APPENDICIES

TO ACCOMPANY ARCHITECTURAL DESIGN REPORT PREPARED BY

DKO Architecture

DESIGN REVIEW SUMMARY

DS-12 Interface Section - Driveway
Scale 1:100

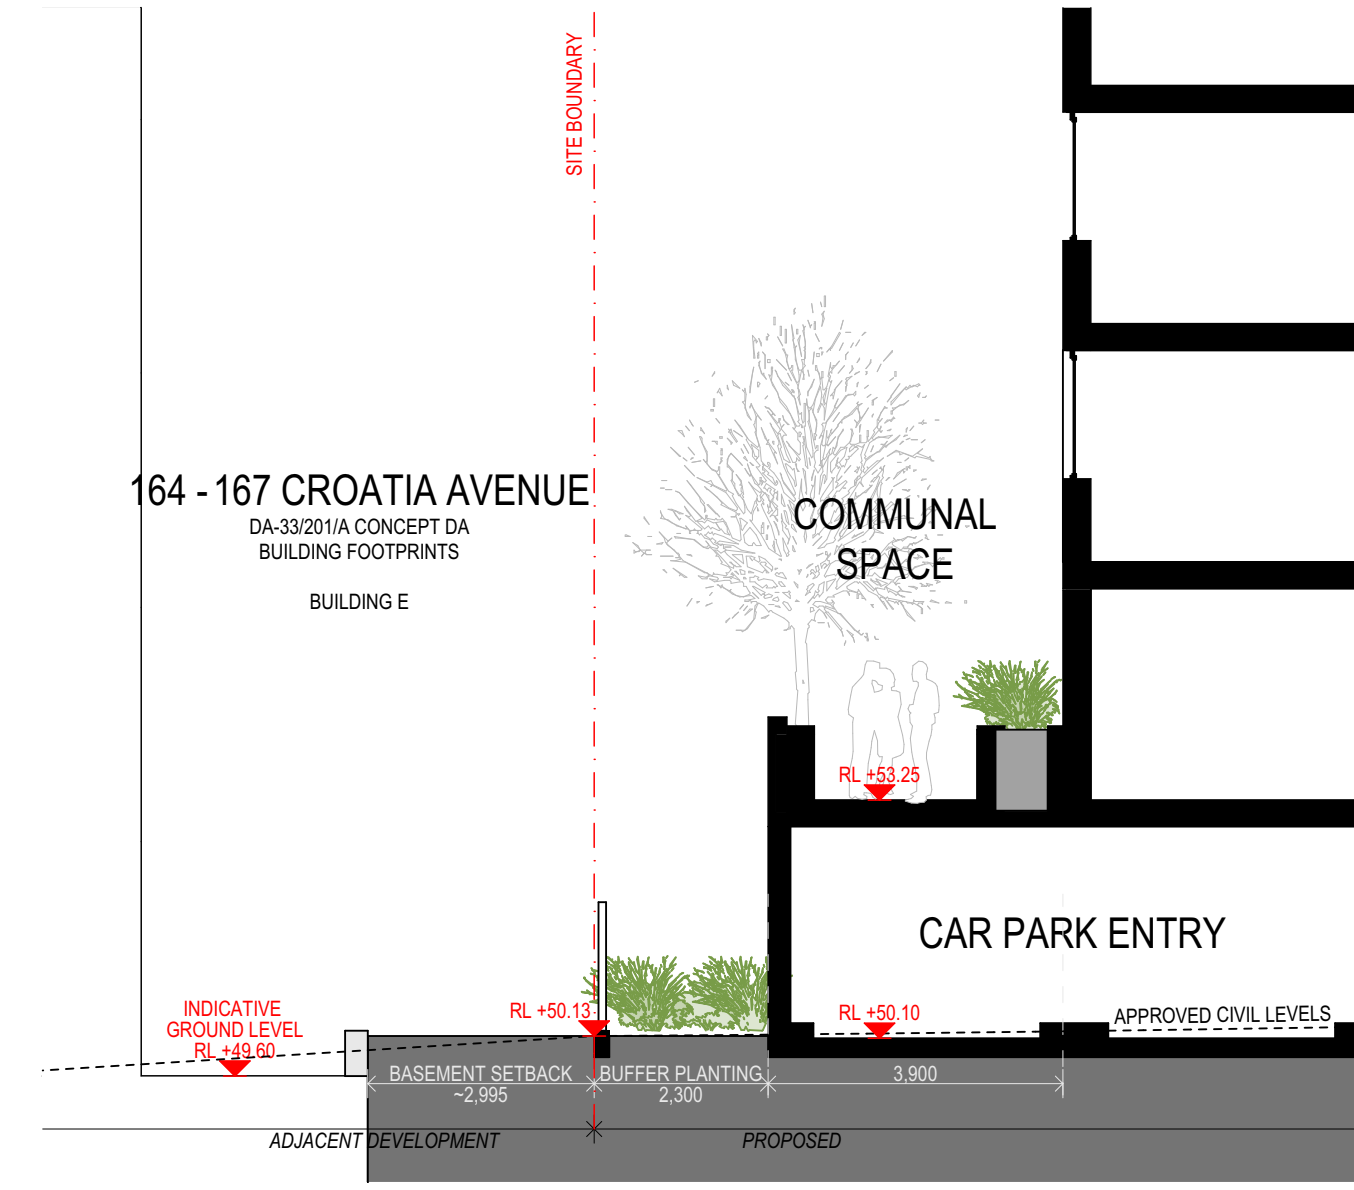
5. Landscape 5.1. CDPD is supportive of the project’s aims to achieve 40% canopy. 5.2. CDPD requests public domain interface sections illustrating the relationship between the ground and level 1 apartments, the interface with the public domain at the site boundary, footpaths, road reserve and kerb. There are crash barriers, retaining walls and level changes along Soldier’s Parade that should be illustrated on future drawings. 5.3. CDPD recommends tree and plant species selected are native and endemic to the area. CDPD requests clarity on where the species selection is being informed by – the Connecting with Country consultation, MOD 5 and/or the Liverpool Growth Centre Precincts DCP recommended species. Liverpool City Council recently released the Draft Tree Management Strategy and Technical Guidelines that should be referred to for further information and tree species and planting details. Draft Tree Management Framework Liverpool Listens 5.4. CDPD notes street trees are shown on the drawings, and seeks confirmation that the Street Trees will be delivered, as part of this project. Further detail such as spacing, pot size, planting details should be provided, and how this relates to the broader street tree approach of the Edmondson Park Town Centre and MOD 5.	5.1. Due to the bushfire requirements, we have had to reduce the canopy cover to 15%. 5.2. Public domain sections have been provided. 5.3. Endemic species have been nominated. This was informed in consultation with the Connecting with Country consultants, and research into the Cumberland Plain species and the council recommended species. 5.4. Street trees have been documented and will be delivered as part of the project. In consultation with WSP it was recommended a native species be used instead of the Fraxinus originally approved.
